DECISION DELEGATED TO HEAD OF PLANNING

Application No: H14-0983-22 **Applicant:** Mr N Odedra

Proposal: Conversion of existing building to provide a local convenience store, to include new front elevation design, shutters, condensing units external works and extension of opening hours

Location: 75 Church Street Pinchbeck Spalding

Proposed GF Plan & Elevations

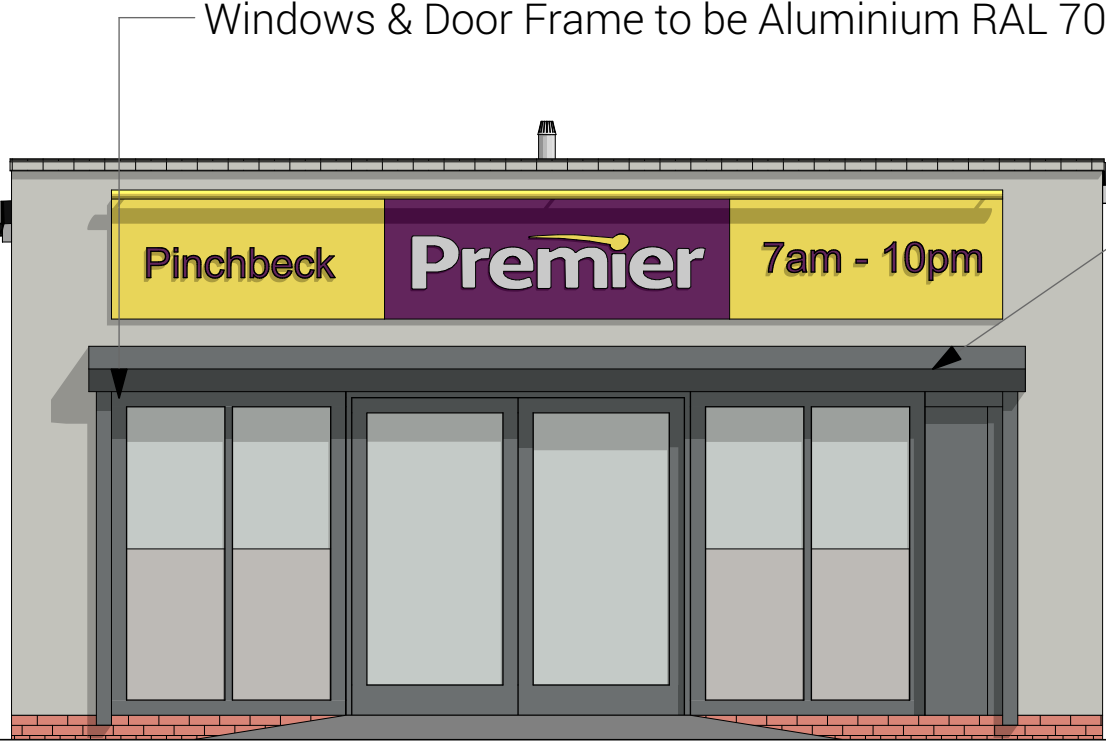
Appendix 6 of the SELLP 2019 requires 1 parking space per 14m², however, on the proposed plans there is approximately 3 car parking spaces indicated. The store would have to provide a minimum of 6 customer parking spaces for the proposal to be considered acceptable.

However, notwithstanding the comments of The Local Highway Authority the proposal is contrary to Appendix 6 of the SELLP 2019, requiring 1 parking space per 14m².

Furthermore, there is not sufficient space for customer parking within the proposed site in the context of Appendix 6 of the Local Plan.

Proposed West Elevation 1:50

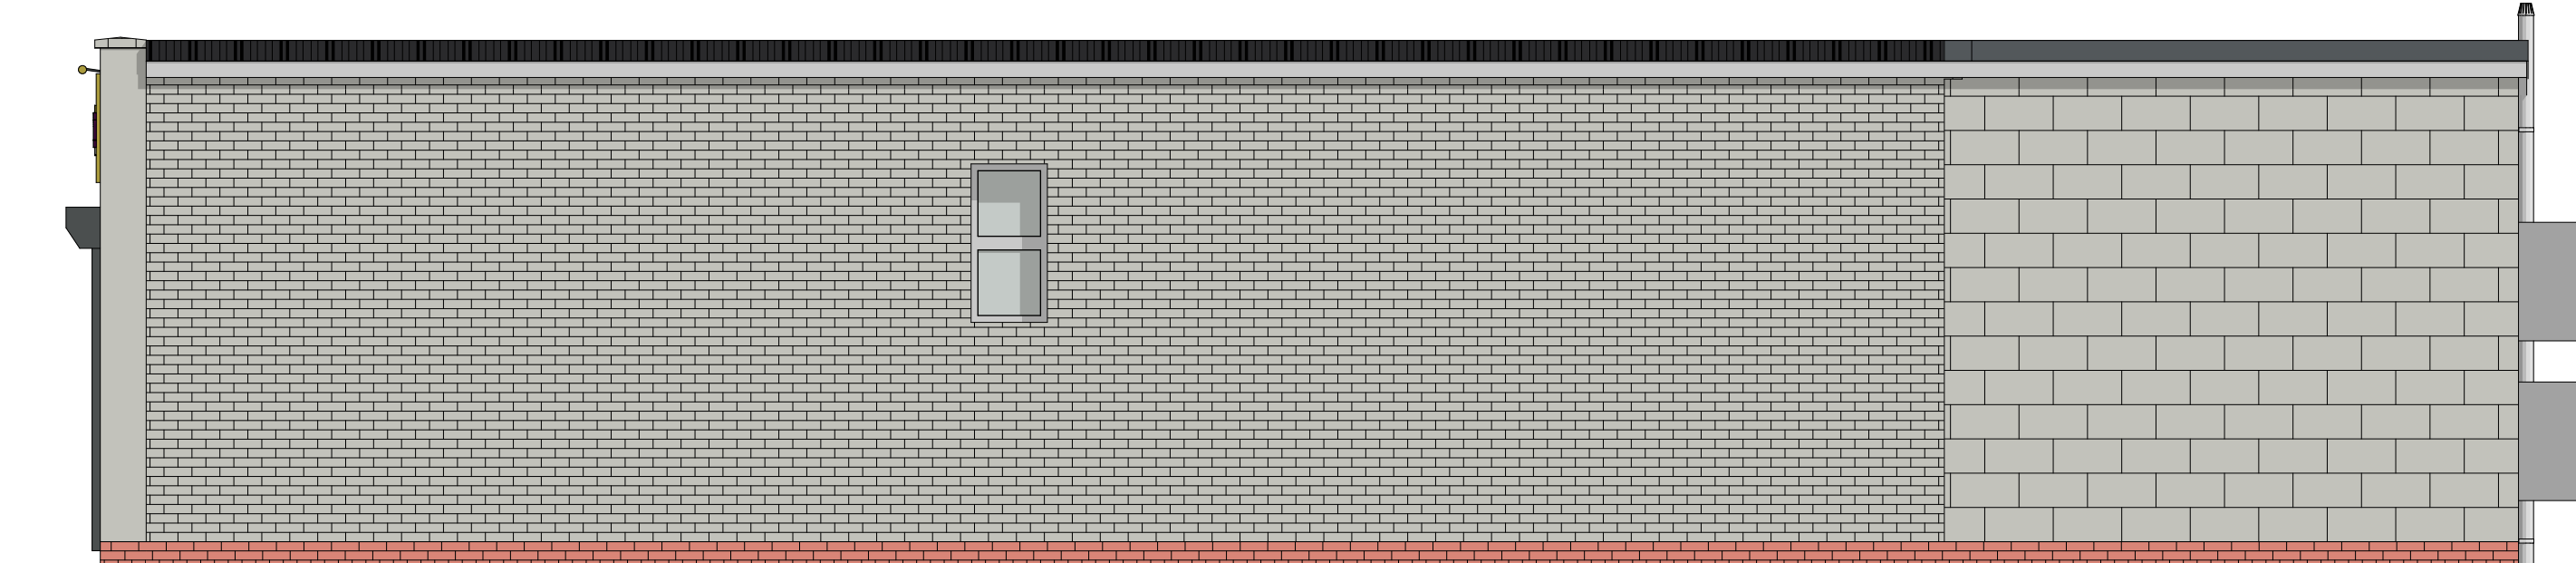
The proposal involves alterations to the front (west) elevation of the building, comprising of the creation of a new opening with a security roller shutter and new signage. The proposed changes to the front elevation are not considered to unacceptably change the overall appearance of the site. To the rear (east) there are four condensing units proposed. The units will not be visible from the road, and it is therefore considered there will be no adverse impact to the street scene. The rest of the building will remain largely untouched.

The application site is located to the edge of Pinchbeck Conservation Area with older terraced properties to the north and more modern dwellings to the south and east. The building is also located within the street scene of Pinchbeck Hall which is a listed building to the north west. The alterations to the front elevations are not expected to harm the street scene or setting of the listed building the grounds of which are hidden by landscaping along its boundaries. Visually the proposed alterations to the building would not be much different to the Mace store on Knight Street, which is not particularly characterful, and is closer to a Listed Building than the application site. It is also not considered to be harmful to the visual amenity of the Conservation Area.

Proposed East Elevation 1:50

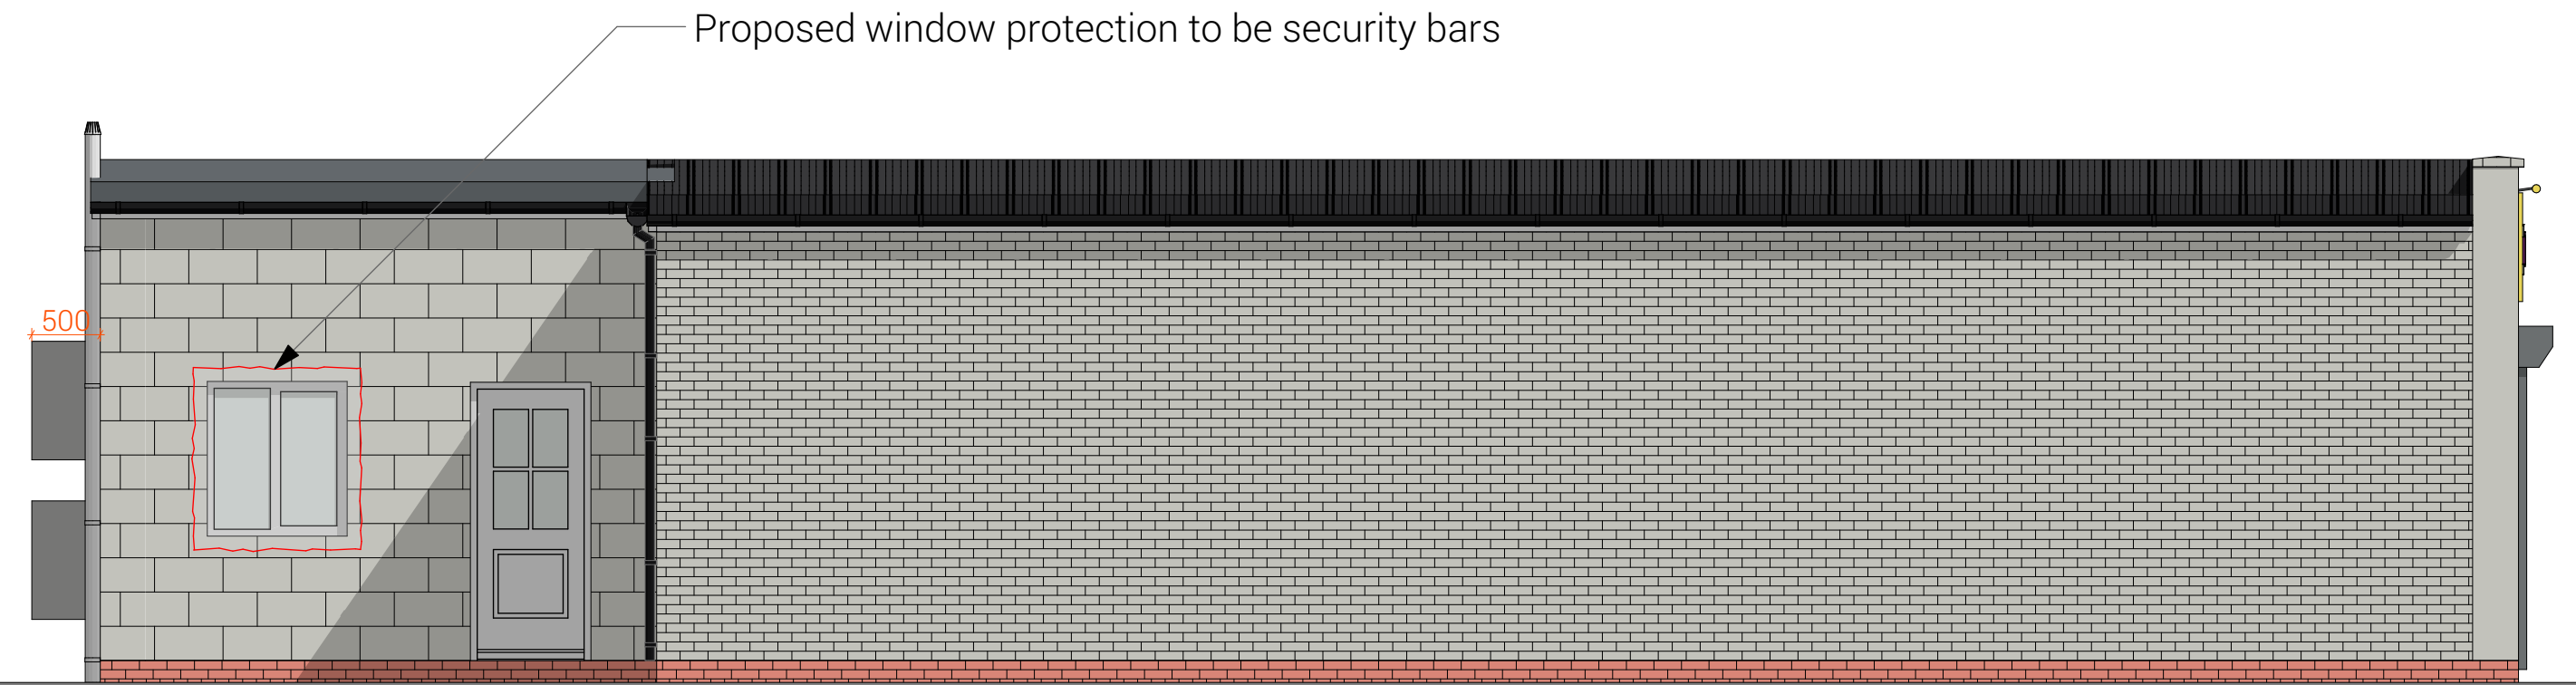
I have some concerns regarding potential delivery hours and noise from the proposed condenser units.

SHDC's Environmental Protection Officer has raised concerns regarding potential delivery hours and noise from the proposed condenser units and that they would be looking to impose a noise condition for the condenser units and would look to restrict delivery hours. This matter has not been explored further given the issue of principle.
